Consultation Response from: KC Environmental Health (Pollution & Noise Control)
2024/91821 - Land Adj 56 Low Road, Dewsbury Moor, Dewsbury, WF13 3PR
Erection of commercial unit for use as a Vehicle Testing and Repair Garage with associated external works
Date Responded:
24 July 2024
Responding Officers:
NH & MN
Responding Ref:
WK/202422236
Noise

Appendix 4 – Scheme Of Noise Mitigation

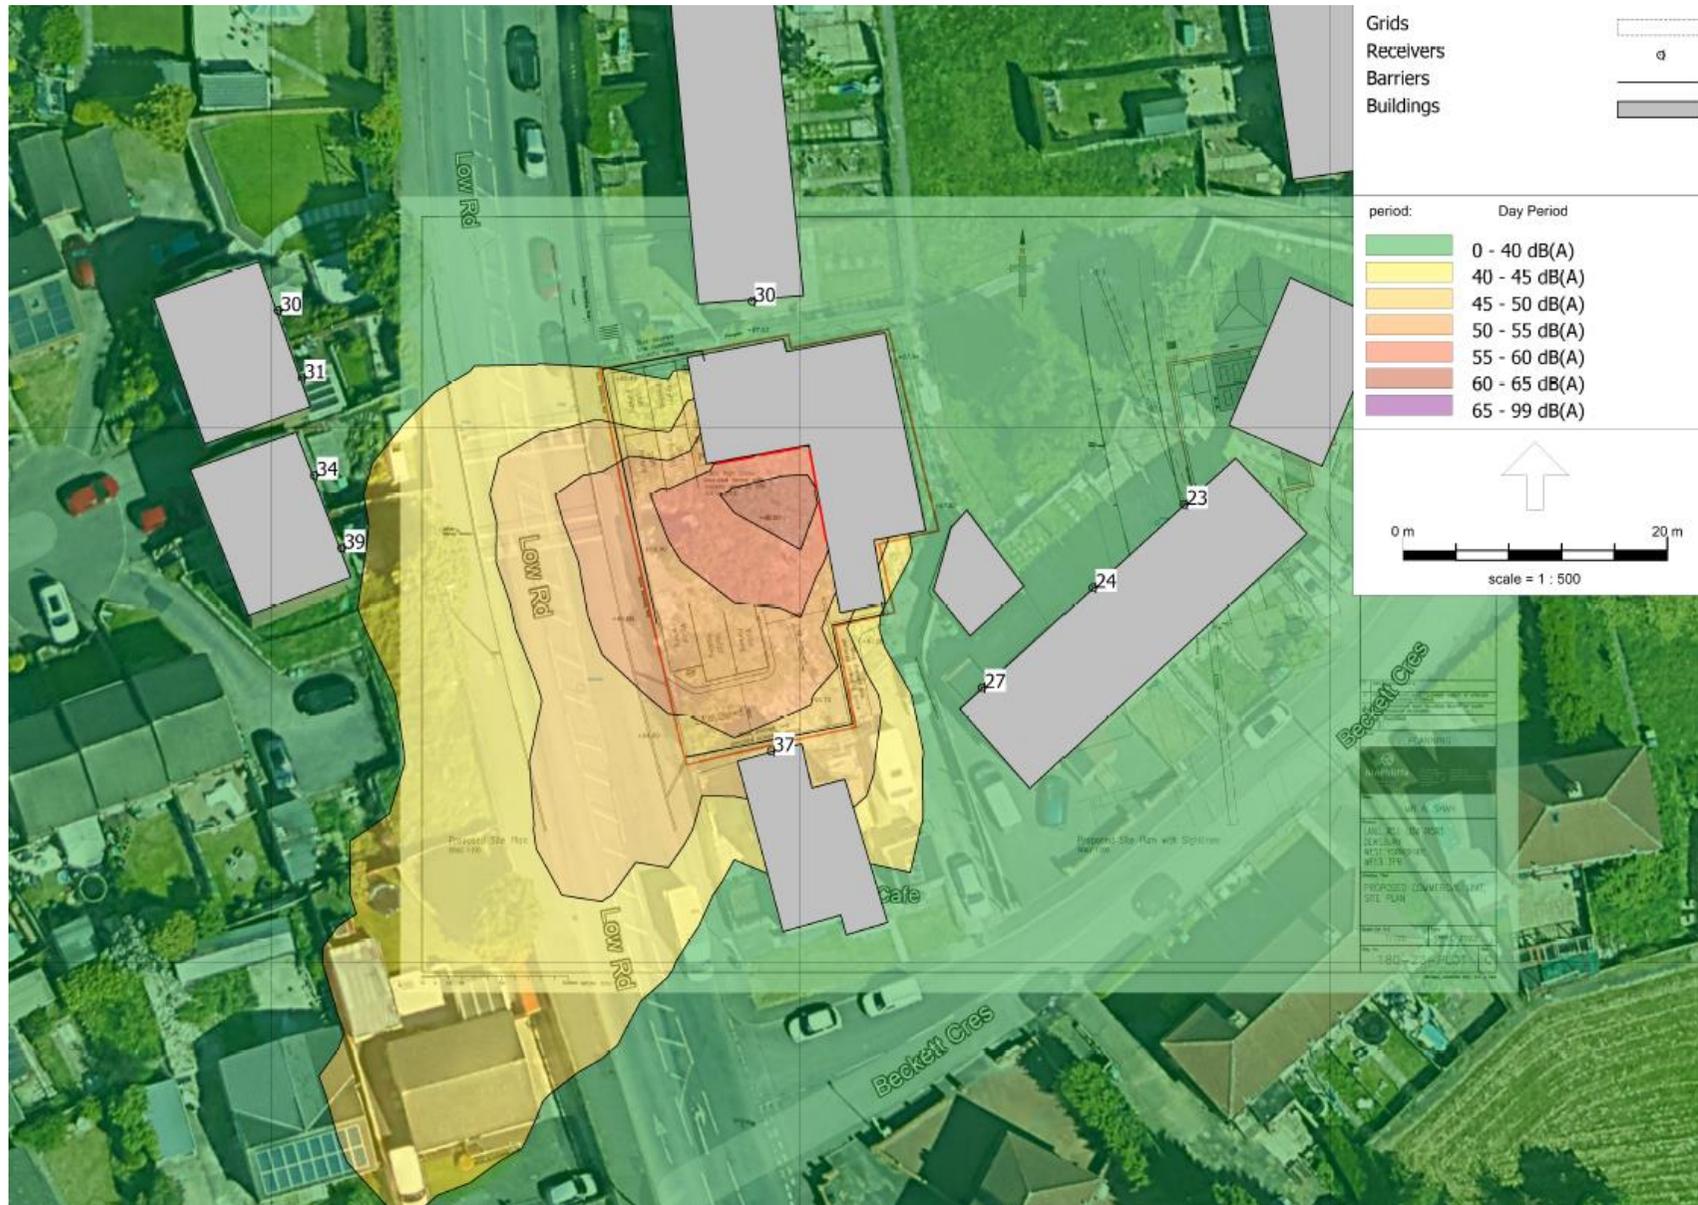
1. The Planning Statement from Hinchcliffe states an Air Source Heat Pump is to be installed but this is not reflected in the submitted Noise Impact Assessment nor in any of the plans.
2. Drawing no. 180-23-PL05 from Hinchcliffe details a proposed acoustic fence which is also reflected in the site plan drawing no. 180-23-PL01. Comment is made to refer to the ENS noise report but this is not mentioned as a mitigation measure in the aforementioned report.
